PLANNING AMENDMENT

Application No: H08-0591-10-A2

Description: Car lot including change of use of existing shop to car showroom

RE: PROPOSED CAR LOT INCLUDING CHANGE OF USE OF EXISTING SHOP TO CAR SHOWROOM AT 1 SPALDING ROAD, GOSBERTON FOR MR R HUSSAIN - PLANNING APPLICATION REFERENCE H08-0591-10

SITE PLAN

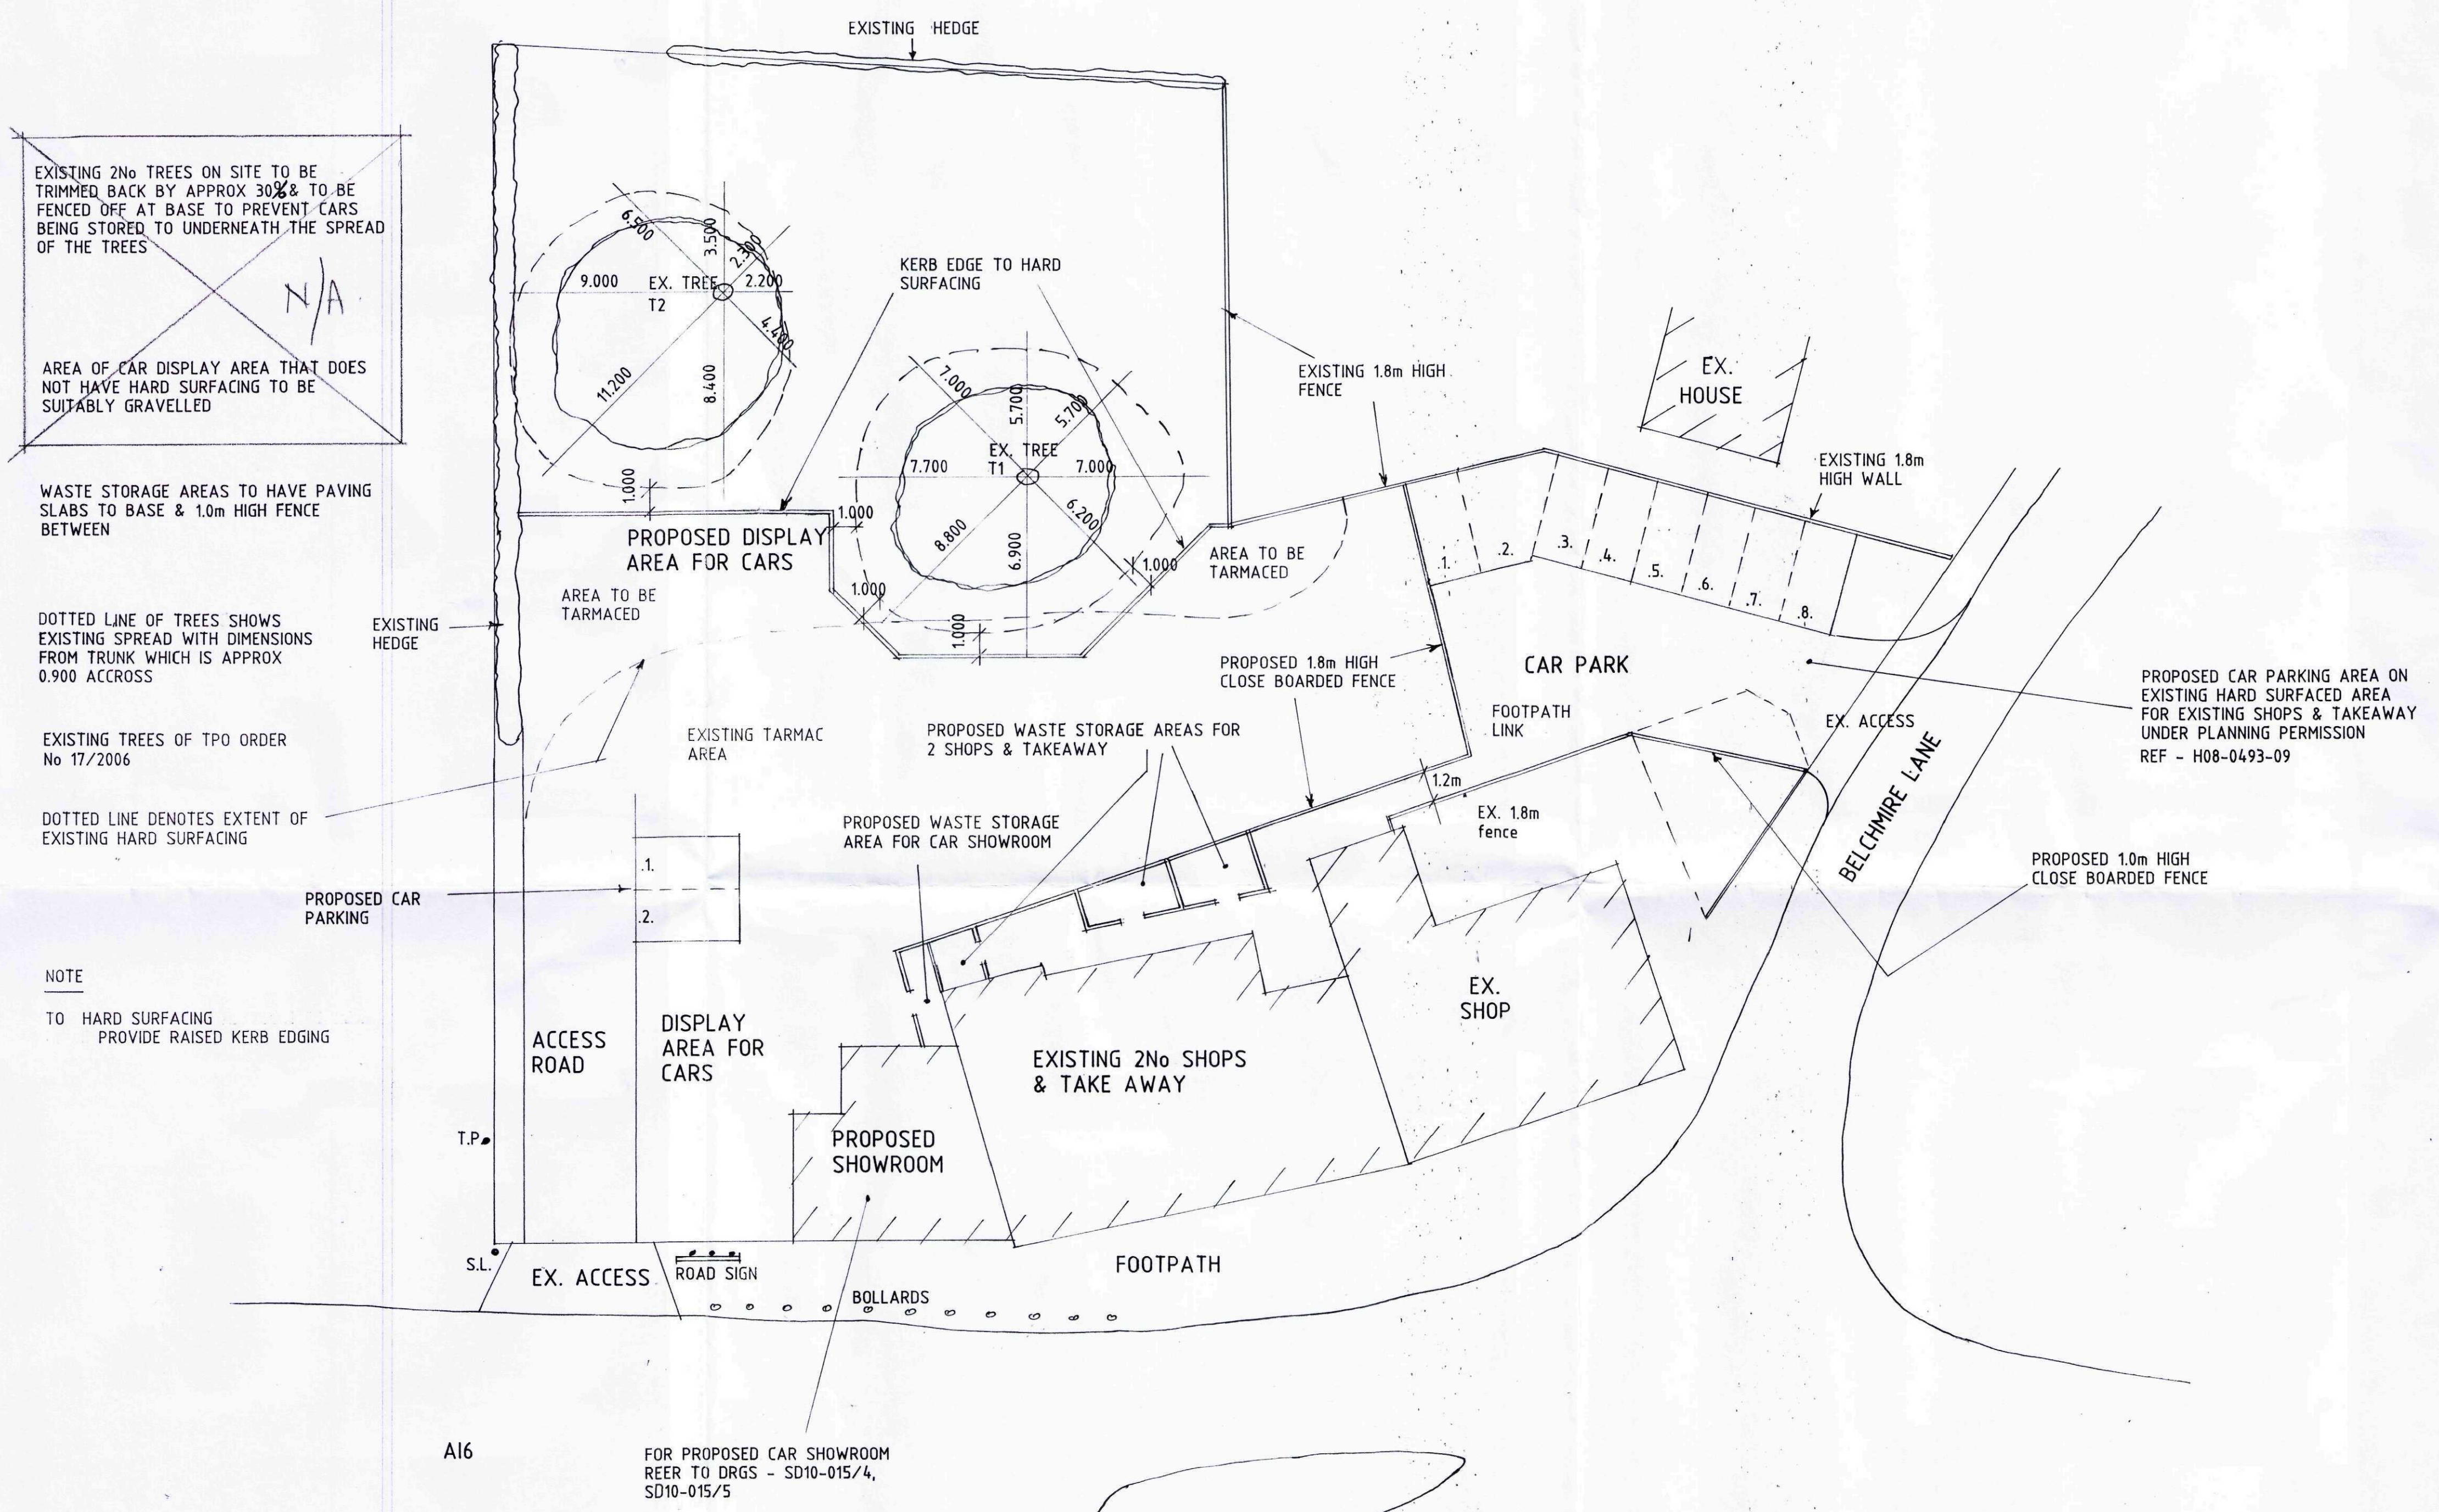
Amendment: Fence to rear of car display area removed
Dwg. no. SD10-015/6D

Further to the recent revised details sent to you on 23 September 2010 in respect of the above, my client has now decided to remove the fence along the edge of the proposed display area for cars.
